Planning Inspectorate

Our ref: OR-0002198/01

Date: 04 June 2026

Application by Photovolt Development Partners (“the Applicant”) for an Order granting Development Consent for the proposed Botley West Solar Farm (“the Proposed Development”)

**Illustrative Masterplan
Figure 5.5C: Cable Corridor Option C**

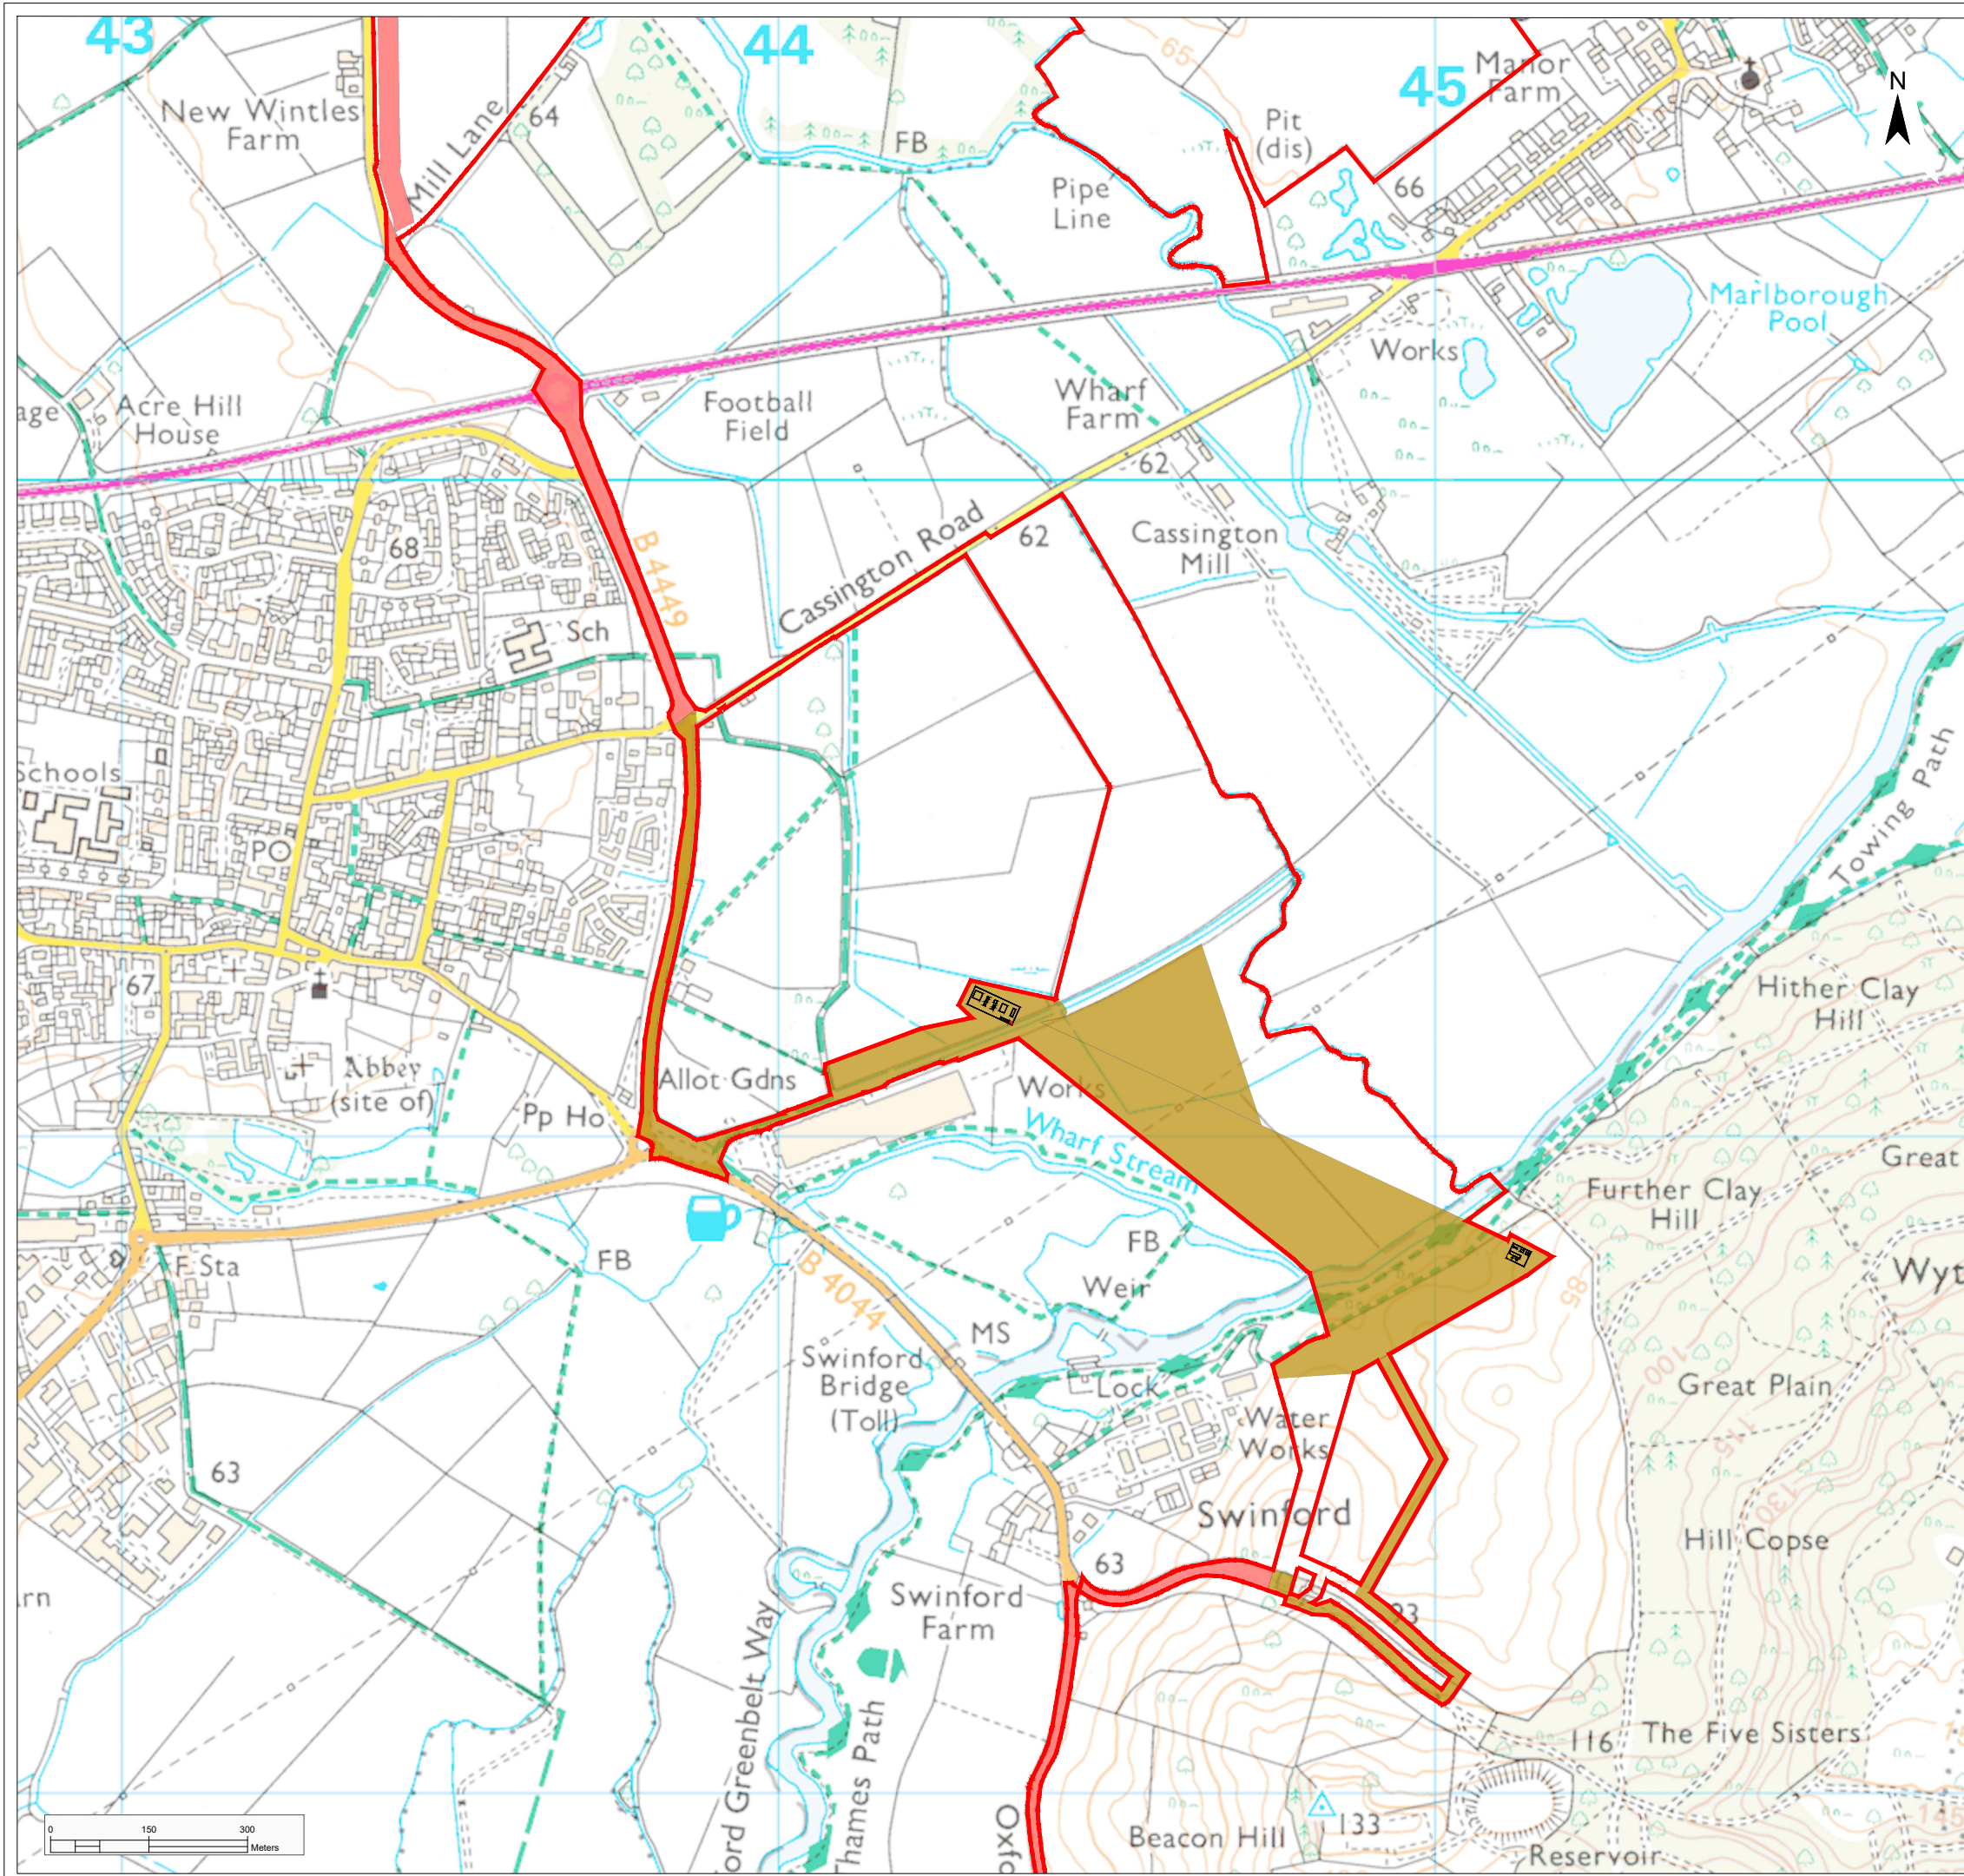
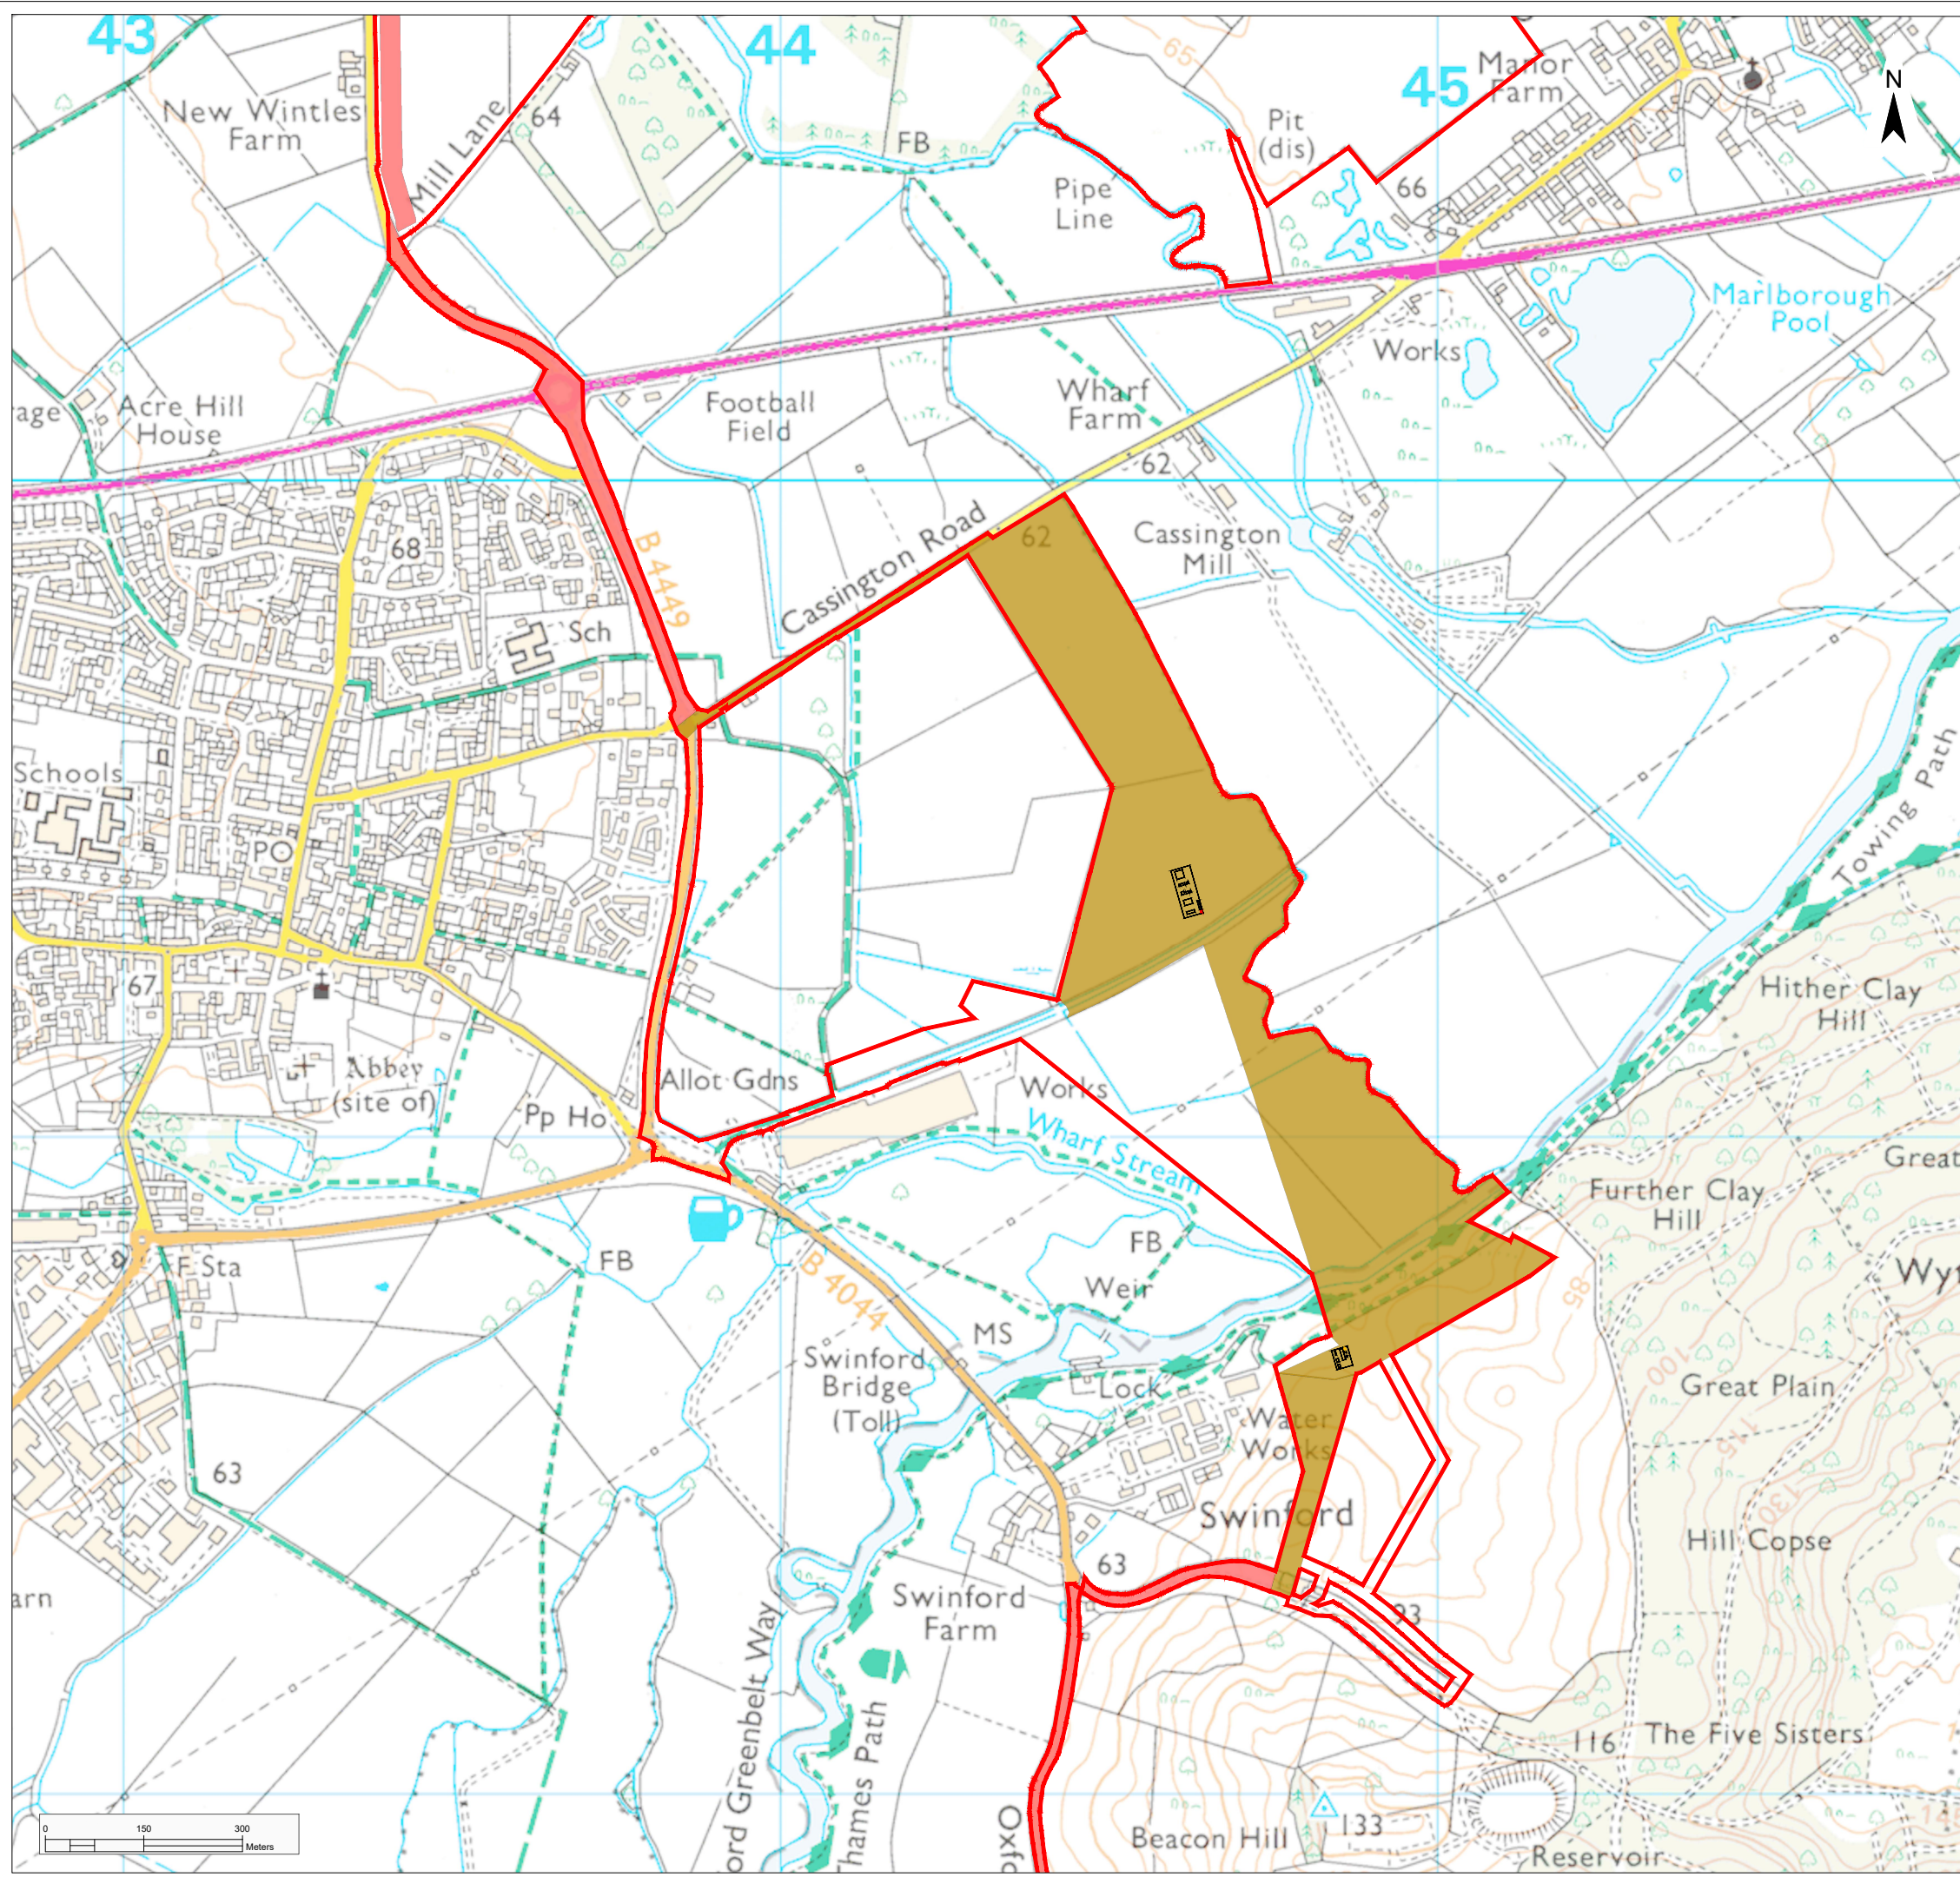
We have reviewed the Hydrology and Flood Risk Technical Note – Swinford HDD Crossings (REP6-054). The applicant has adequately justified why they are unable to move the Horizontal Directional Drilling (HDD) entrance pit at Swinford outside of Flood Zone 3b. We consider this justification is reasonable in the context of wider site-specific constraints.

Considering the proposed mitigation measures, inclusive of the additional mitigation measures (section 1.4.4), if the applicant complies with these, we consider that the approach is reasonable.
